Your Ref :
Our Ref : FG/27/14/NMA

Application for non-material amendment following grant of planning FG/52/12 - reduce window & extend roof
18 Oval Way, Ferring, .

PROPOSED SOUTH ELEVATION 1:100

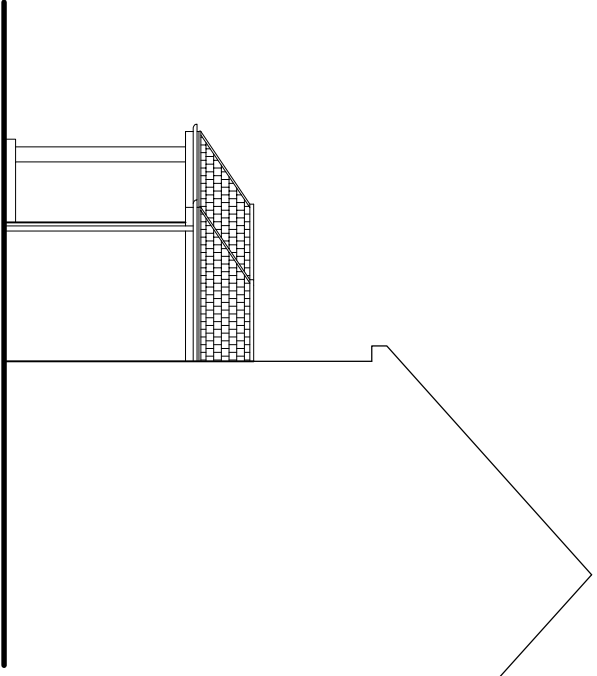
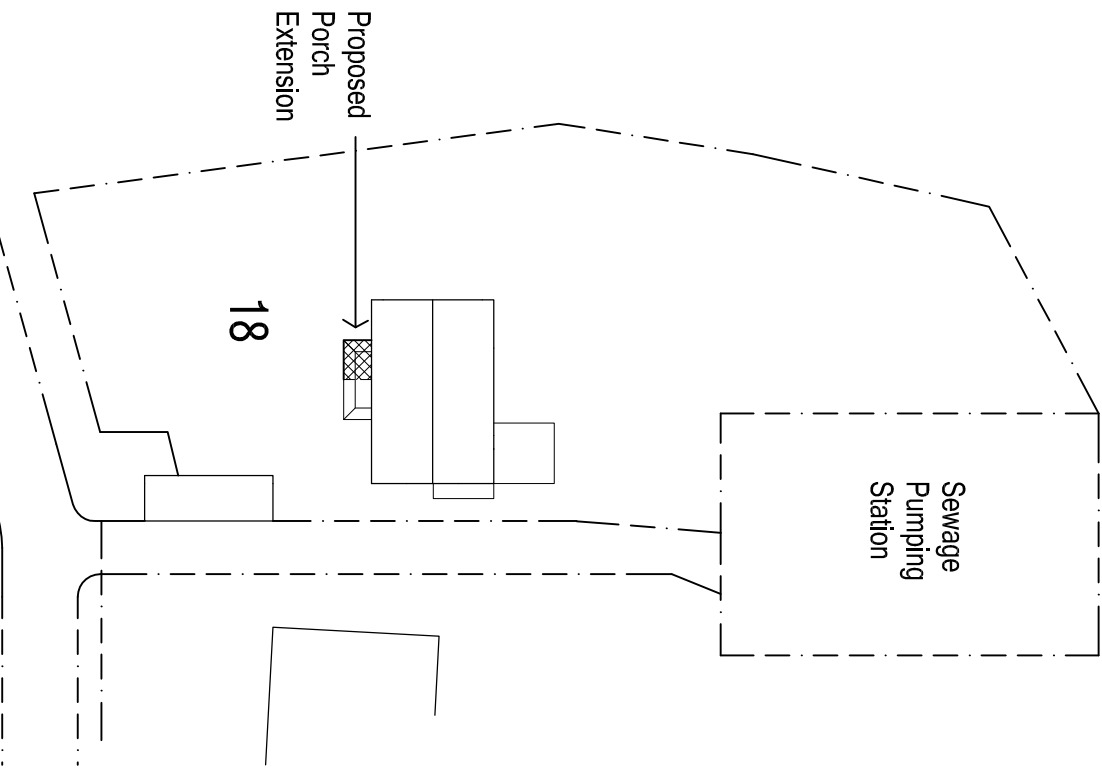
I refer to your recent application for a Non Material Minor Amendment. From the information submitted I am satisfied that the revisions proposed; namely increasing the roof projection by 1m and inserting a rectangular window in the south elevation of the porch extension can be taken as a Non Material Amendment to planning permission FG/52/12.

Please note that the extract plan submitted with this application under drawing number 8832/1 (Block plan, Existing and proposed elevations and Ground floor plans) has become the approved plan in relation to the porch extension and replaces the plans approved under FG/52/12 in this respect.
